Green spaces, mental health, Public Rights of Way and Economic Impacts

Potential impacts of Greenhill Solar Development

Title:
Figure 13.12: Public Rights of Way within the
Study Area (South Area)

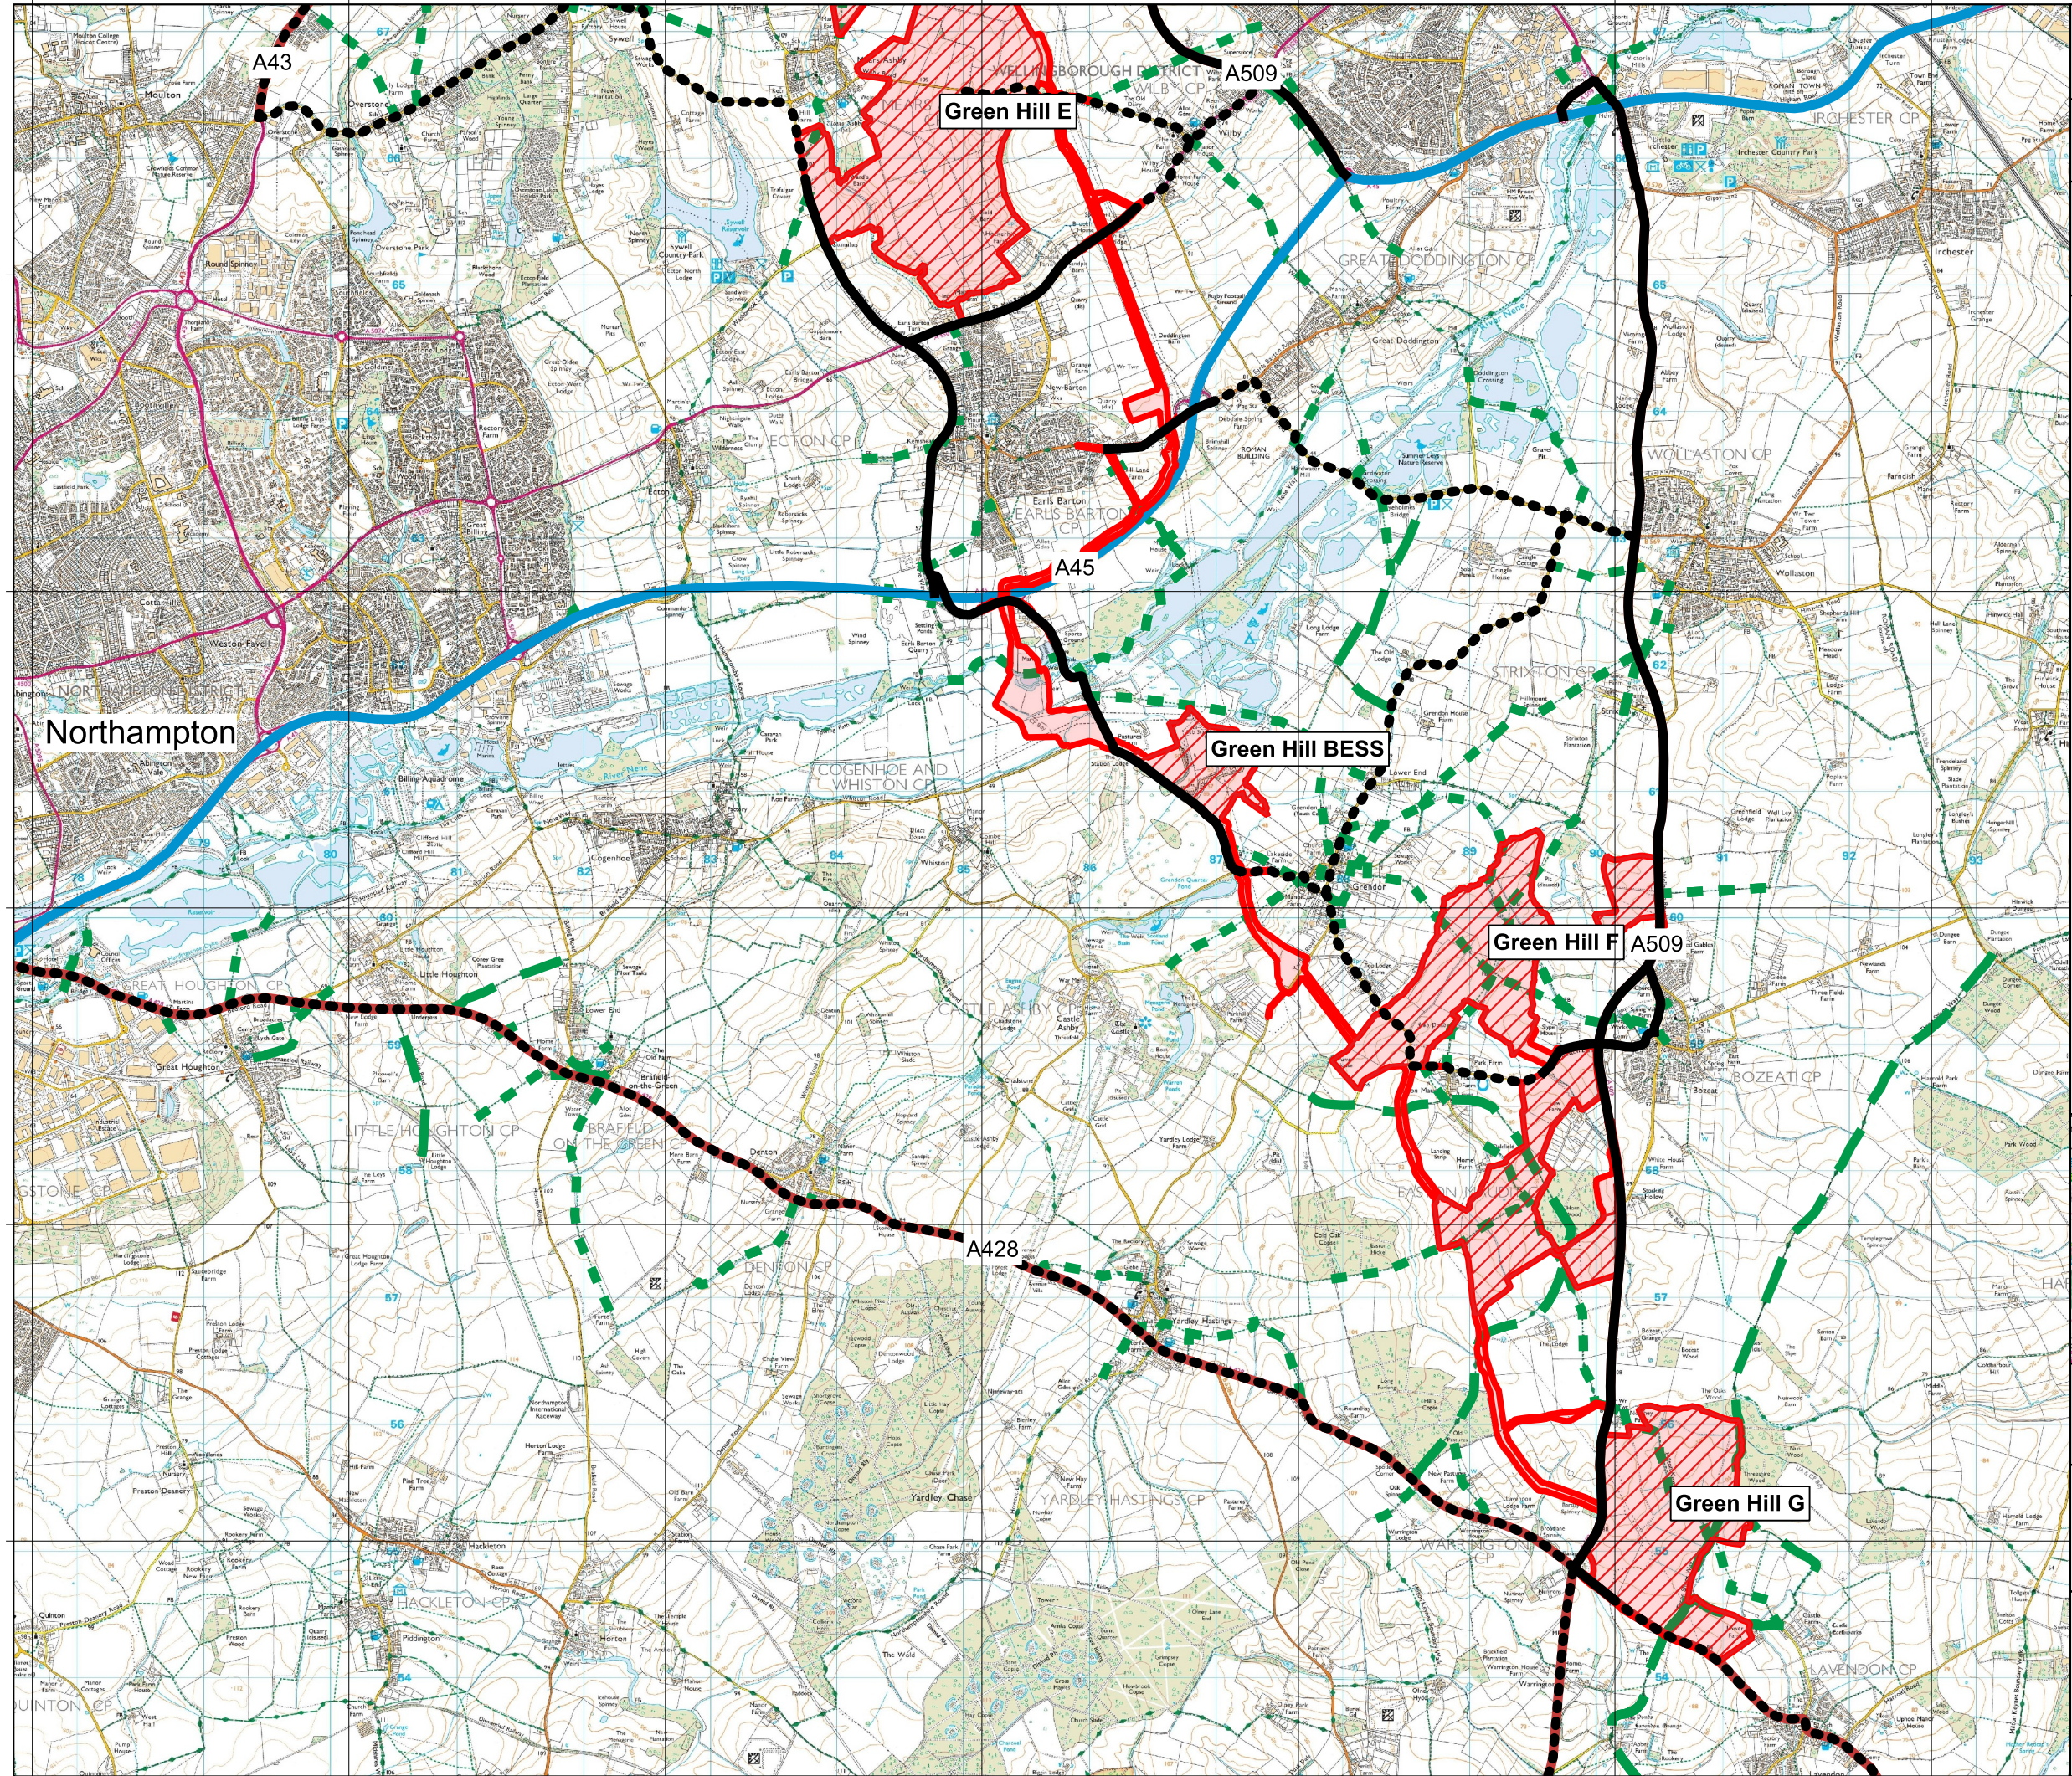
3.2 Public Rights of Way will be restricted, moved, or at least for periods of time, completely blocked by development proposals. 18.6.41 refers to the ES Appendix 17.1 as identifying “a total of 70 PRowS and permissive recreational routes”. Of these there are five which are cited as “inter-settlement infrastructure”. Oddly excluded from that list is the footpath from Grendon to Castle Ashby. It is understood (APP/GH2.6 TP182) that this footpath will be closed for access for construction traffic

to construction compound 2 and cable laying (presumably for a 2-year construction period). A photograph of where this interrupts the footpath is appended (Appendix 1a).

3.3 The second example footpath is near Easton Maudit and listed as TP206 This borders a field to be assigned to solar panelling, and which will have fencing and hedging at the nearer edge resulting in a loss of view and a sense of enclosure. A photograph of this is appended (Appendix 1b).

- 4.1** Comments for Walgrave are relevant. If the analysis is not to be done comprehensively then the application of sensitivities will be inaccurate.
- 4.2** The closing of PROW and its effects have not been effectively measured and hence should be re-rated;
- 4.3** The impact on expectations and hence on health and cognitive effects should be reconsidered.
